Lady Ann Road, Batley

**Residential Development &
Junction Improvement Scheme**

Stage 1 Road Safety Audit Response
11 December 2023

Reference number 1247J

PROPOSED SITE PLAN

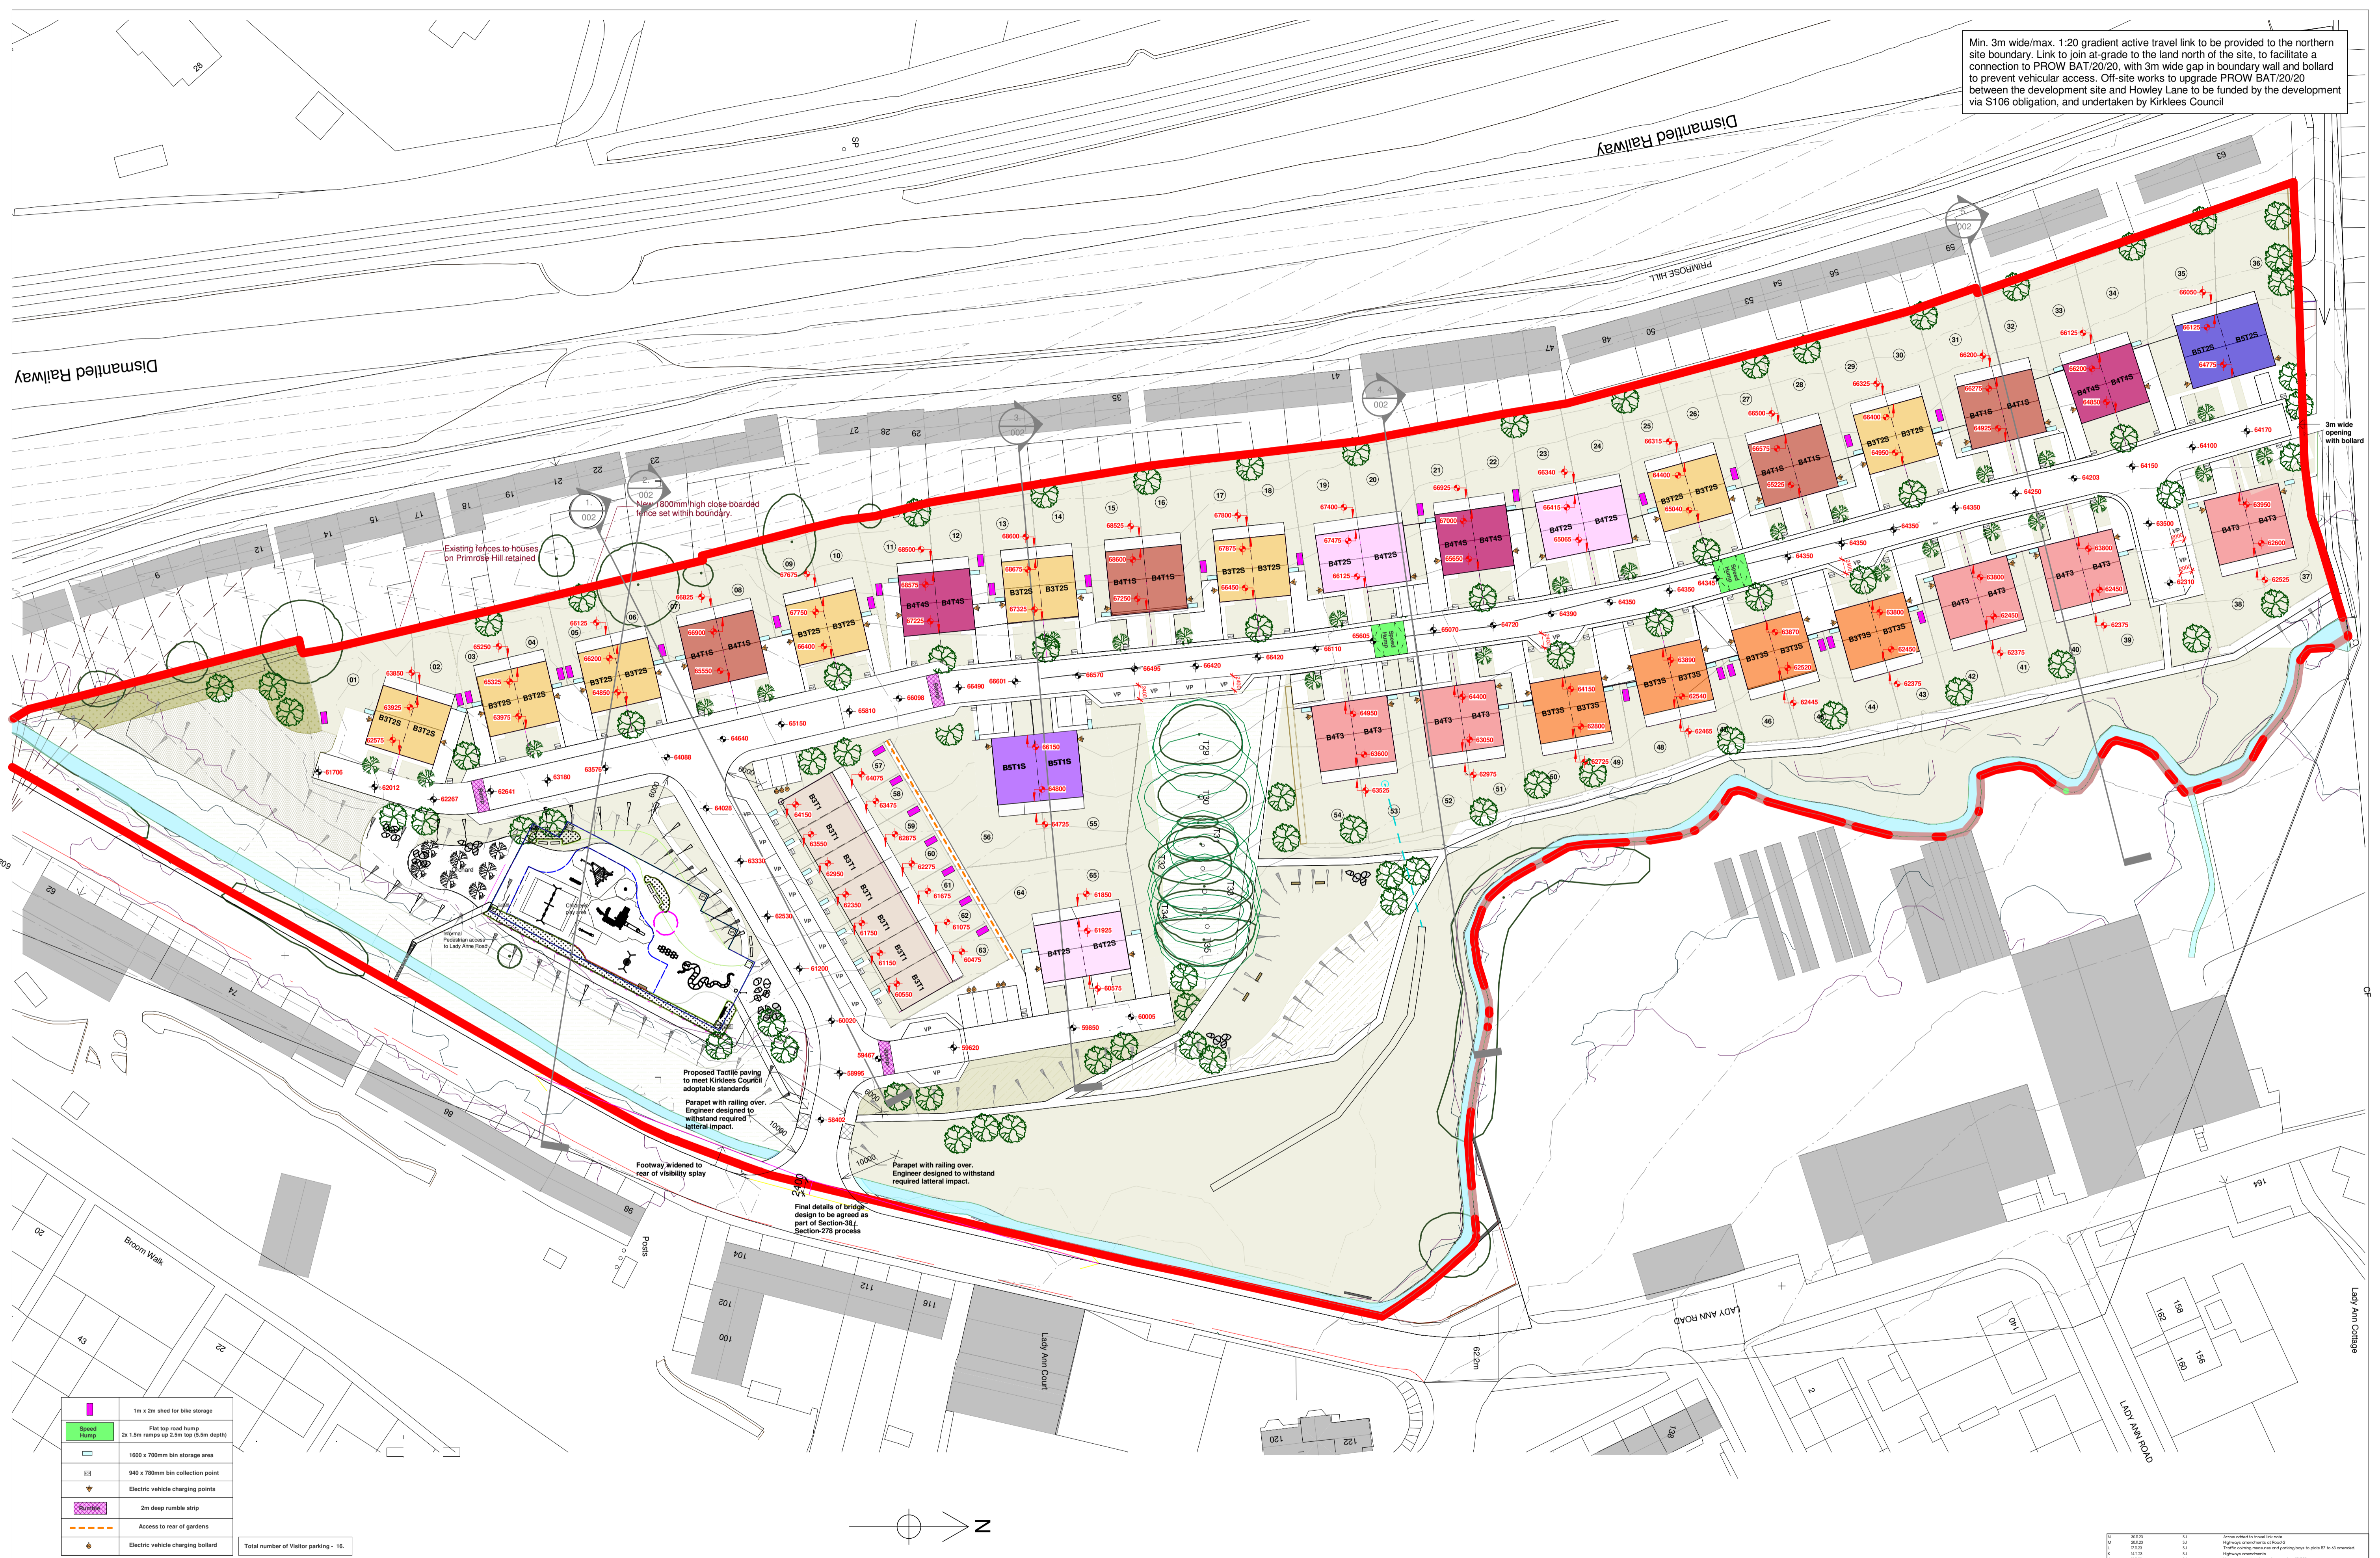
<p>PROBLEM – A-02</p> <p>Location: Main access and internal development roads</p> <p>Summary: Drainage – Insufficient surface water drainage may increase the risk of skidding type collisions at the junction as well as slips and falls by pedestrians</p>	<p>It is recommended that drainage details are provided at the next stage of road safety audit including gully locations, levels and contours</p>	<p>Accepted – drainage proposals will be provided at detailed design stage</p>	<p>The RSA problem and Design Team response is accepted</p>	<p>Drainage proposals to be agreed at the detailed design stage</p>
<p>PROBLEM – A-03</p> <p>Location: Internal development roads – Road 1 and Road 3</p> <p>Summary: Skidding Resistance – Insufficient skidding resistance may increase the risk of loss of control type collisions</p>	<p>It is recommended that a minimum 55 PSV is provided where gradients exceed 5% and that inspection chamber covers provide a similar level of skidding resistance to the surrounding carriageway surface</p>	<p>Partially Accepted – suitable PSV shall be provided to meet KMC adoptable standards</p>	<p>The RSA problem is partially accepted and Design Team response is accepted</p>	<p>Surfacing and cover PSV values to be agreed at the detailed design stage</p>

<p>PROBLEM – A-04</p> <p>Location: Existing Watercourse and Wetland Areas</p> <p>Summary: Fences and Road Restraint Systems – Lack of barrier protection to the existing beck may increase the risk that pedestrians or other road users enter the beck or wetland areas and sustain injuries or drown</p>	<p>It is recommended that a barrier treatment proportionate to the level of risk is provided between the beck/wetland areas and areas where pedestrians and other road users may use.</p> <p>It is also recommended that any parapet arrangement over the beck is located to the back of the junction visibility envelope of the development access onto Lady Ann Road</p>	<p>Accepted – suitable barrier treatment will be provided and identified as part of the detailed design. The parapet arrangement is located to rear of the visibility splay</p>	<p>The RSA problem and Design Team response is accepted.</p> <p>However, it is noted that the submission plans already note the requirements suggested by the RSA Team</p>	<p>Pedestrian & vehicle restraint proposals to be agreed at the detailed design stage</p>

<p>PROBLEM – A-05</p> <p>Location: Internal development roads</p> <p>Summary: Specific Road Users – Lack of dropped crossings on desire lines may increase the risk of collisions involving users with mobility issues</p>	<p>It is recommended that a dropped pedestrian crossing with (ideally) tactile paving should be provided at these locations. Specific locations will need to consider the risk of vehicle overrun damage to the tactile paving by large vehicles, in particular refuse collection vehicles.</p> <p>Including but not limited to;</p>	<p>Accepted – additional dropped crossings will be provided as agreed with KMC as part of the detailed design.</p>	<p>The RSA problem and Design Team response is accepted</p>	<p>Pedestrian crossing proposals to be agreed at the detailed design stage</p>

<ul style="list-style-type: none">- Across Road 1 – Across junction mouth- Across Road 1 – Around Chainage 30m- Across Road 1 – Around Chainage 70m- Across Road 2 – Across junction mouth- Across Road 3 – Around Chainage 25m- Across Road 3 – Around Chainage 45m			
--	---	--	--	--

<p>PROBLEM – A-06</p> <p>Location: Internal development roads – Road 3</p> <p>Summary: Pedestrians – Insufficient provision may increase the risk of collisions involving pedestrians and other active modes</p>	<p>It is recommended that a footway is provided along at least one side of Road 3 for the majority of the road length</p>	<p>Not accepted, the traffic calming provided includes vertical deflections at suitable intervals to enable a 15mph design speed in accordance with KMC design guide</p>	<p>The RSA problem is not accepted, as the use of shared surface streets is acceptable for a development of this scale, in accordance with the Kirklees Council Highway Design guide SPD.</p> <p>The Design Team response is partially accepted, as the traffic calming proposals (Speed humps/tables) have been designed to achieve a 15mph design speed, in accordance with the Kirklees Council Highway Design guide SPD. However, at the detailed design stage, it will be necessary to ensure that pedestrians can safely pass the traffic calming features</p>	<p>The design of the traffic calming features (currently shown as speed humps/tables) to be agreed at the detailed design stage. These must be designed to ensure they are also suitable for pedestrian usage (e.g. with accessible ramps or pedestrian bypass facilities provided, or potentially replaced with buildouts instead if necessary)</p>

<p>PROBLEM – A-07</p> <p>Location: Proposed Development Roads and pedestrian links to adjacent roads</p> <p>Summary: Lighting – Lack of or insufficient carriageway lighting may increase the risk of collisions, trips and falls during the hours of darkness</p>	<p>It is recommended that carriageway lighting is provided on both the development roads and all footway links.</p> <p>It is also recommended that any carriageway lighting provided within the development is located such that columns are clear of being a hazard for manoeuvring vehicles. i.e. not placed between adjacent parking spaces</p>	<p>Accepted, street lighting shall be provided to meet KMC adoptable standards and identified at detailed design stage</p>	<p>The RSA problem and Design Team response is accepted</p>	<p>Lighting proposals to be agreed at the detailed design stage</p>
<p>PROBLEM – A-08</p> <p>Location: Junction of Lady Ann Road and Soothill Road</p> <p>Summary: Skidding Resistance – Insufficient skidding resistance may increase the risk of junction overshoot type collisions</p>	<p>It is recommended that the carriageway on the Lady Ann Road approach is resurfaced and provided with a skidding resistance commensurate to DMRB CD 236, Table 3.3a or Table 3.3b based on the relevant site categories and traffic levels</p>	<p>Partially Accepted, the surface on the Lady Ann Road approach shall be appraised as part of the detailed design stage. Any surfacing works would be agreed with KMC S278 Engineer</p>	<p>The RSA problem is partially accepted and Design Team response is accepted</p>	<p>Surfacing details to be agreed at the detailed design stage</p>

<p>PROBLEM – A-09</p> <p>Location: Junction of Lady Ann Road and Soothill Road</p> <p>Summary: Pedestrians – Insufficient provision may increase the risk of collisions involving pedestrians and other active mode</p>	<p>It is recommended that, in the first instance, a non-passive bollard is provided to protect the tactile dropped crossing on the footway corner from vehicle overrun.</p> <p>Should this be impractical due to statutory undertakers equipment under the footway surface, then construction of the footway and tactile paving in this area should be sufficient enough to withstand regular overrun by large goods and refuse vehicles</p>	<p>Accepted, bollards to be proposed and identified at detailed design stage</p>	<p>The RSA problem and Design Team response is accepted</p>	<p>Bollards to be proposed at the detailed design stage, to prevent vehicle overrun</p>
---	--	--	---	---
